Submission on Modification to Vincentia District Town Centre - Stage 1 - MP 06_0025 MOD 5

The Vincentia Ratepayers and Residents Association is the council-recognised community consultative body for the Vincentia District Centre (VDC) project location.

1 ELEVATION
WEST ELEVATION - MOONA CREEK ROAD

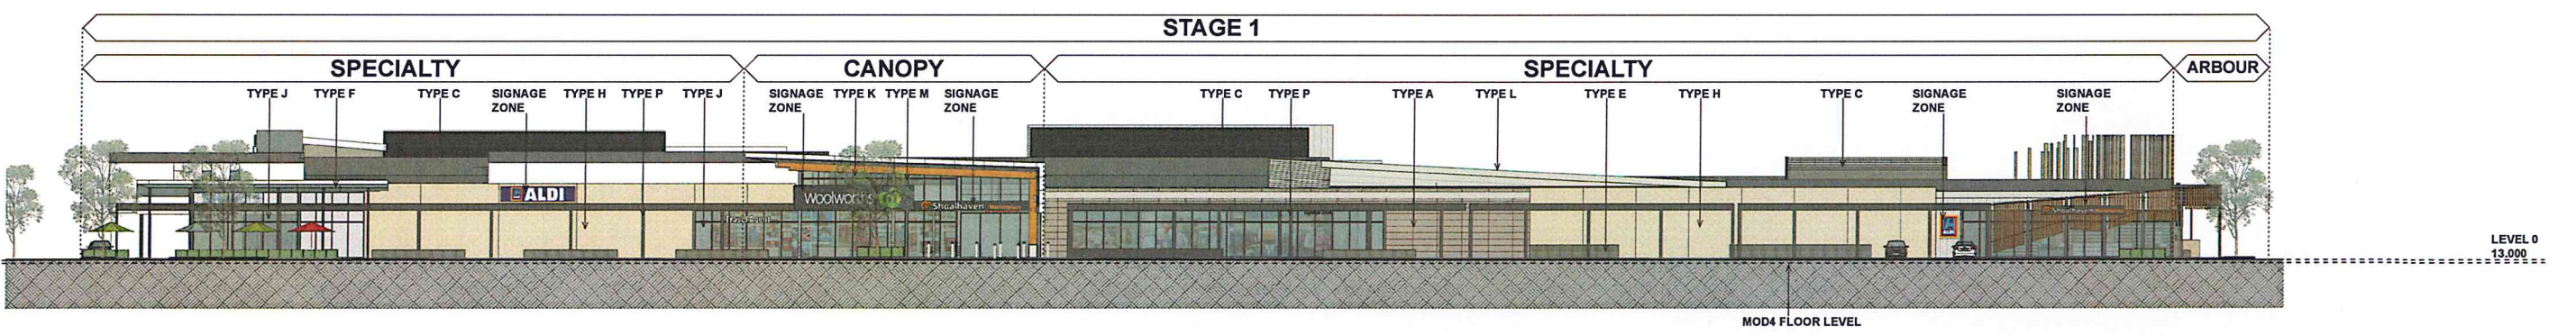
2.6 Moona Creek Road Frontage

Rice Daubney won the design competition having modified the concept of a “main street” such that Moona Creek Road became the main street through the placement of commercial activity to activate that zone.

The proponents have now ignored the concept by removing all commercial activity from Moona Creek Rd. All activity has been absorbed internally, resulting in little more than a generic mall surrounded by carpark. This does nothing to respond to the special environment in which the development is located.

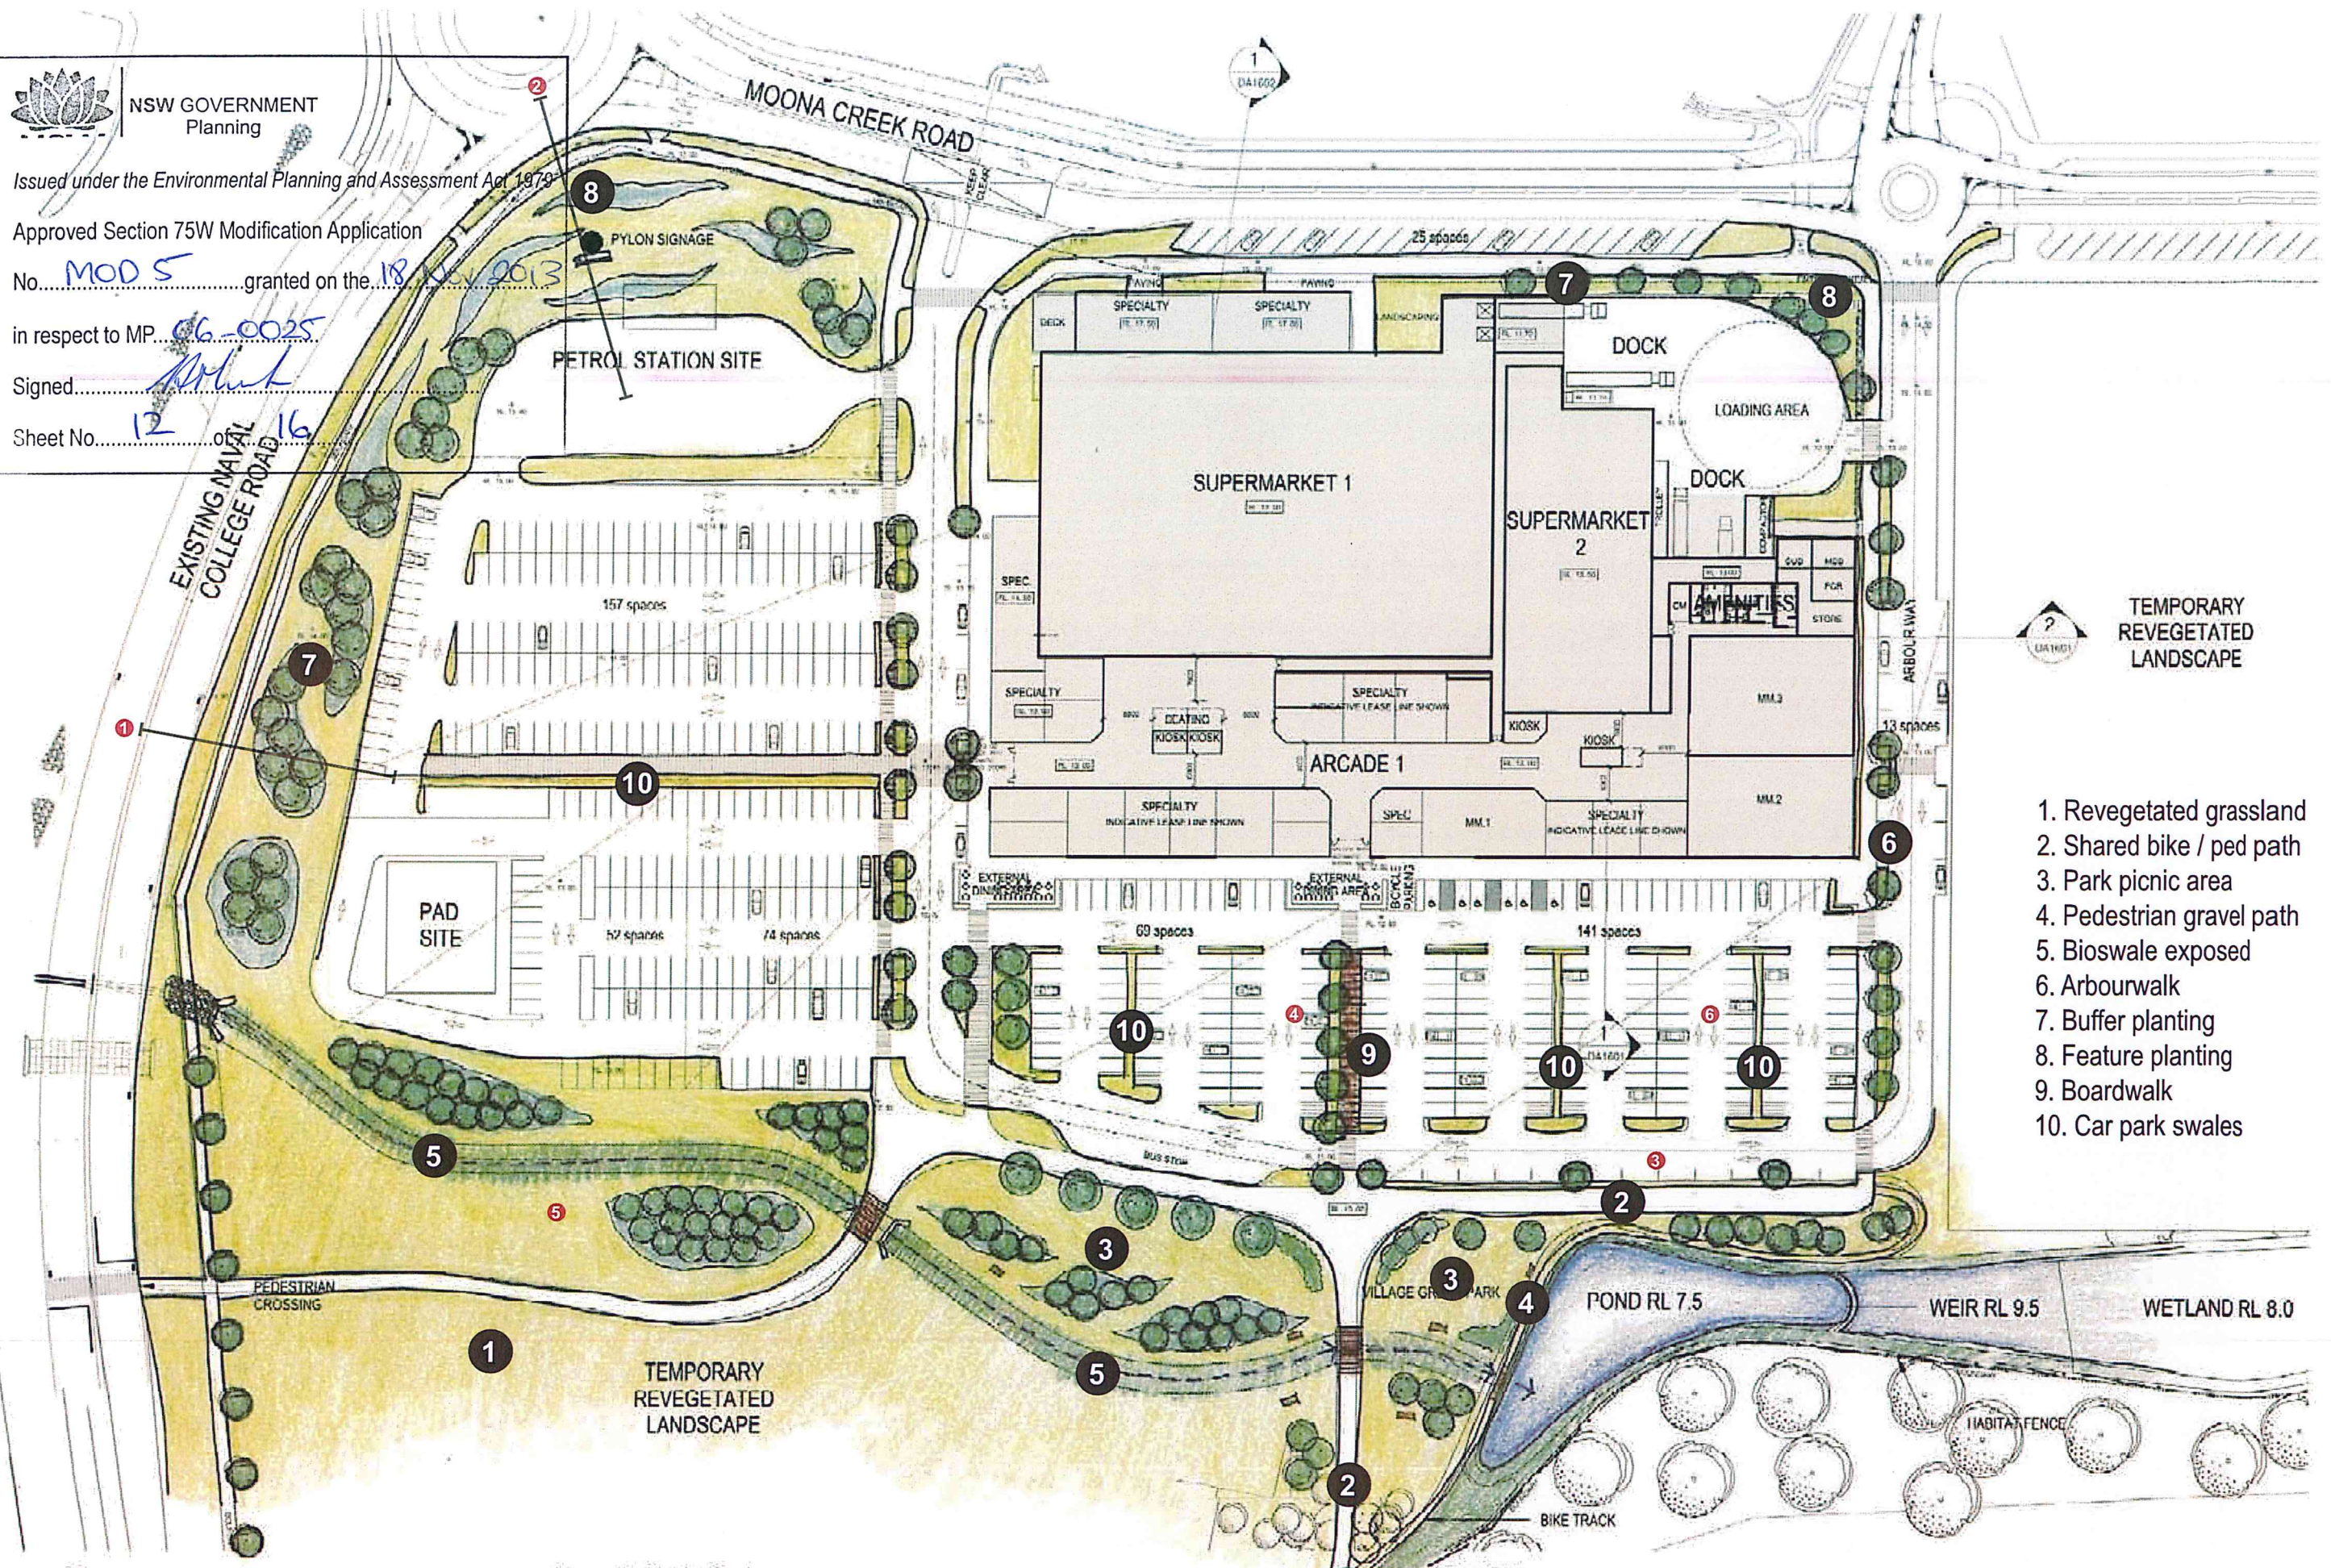
3.3 Car park

Provision for disabled car parking is inadequate. The region has a skewed age population distribution that requires a greater than average provision for disabled parking.

The extensive carpark shows almost no vegetation, creating a stark landscape with little connection to the original and surrounding bushland. Whilst it may be easier for the proponent to build and maintain a fully paved car park, this is at odds with the community's aspiration for a precinct that is both functional and visually appealing.

The 2007 application showed a car park with extensive plantings of *Melaleuca stypheloides* and native understorey. This should remain a requirement.
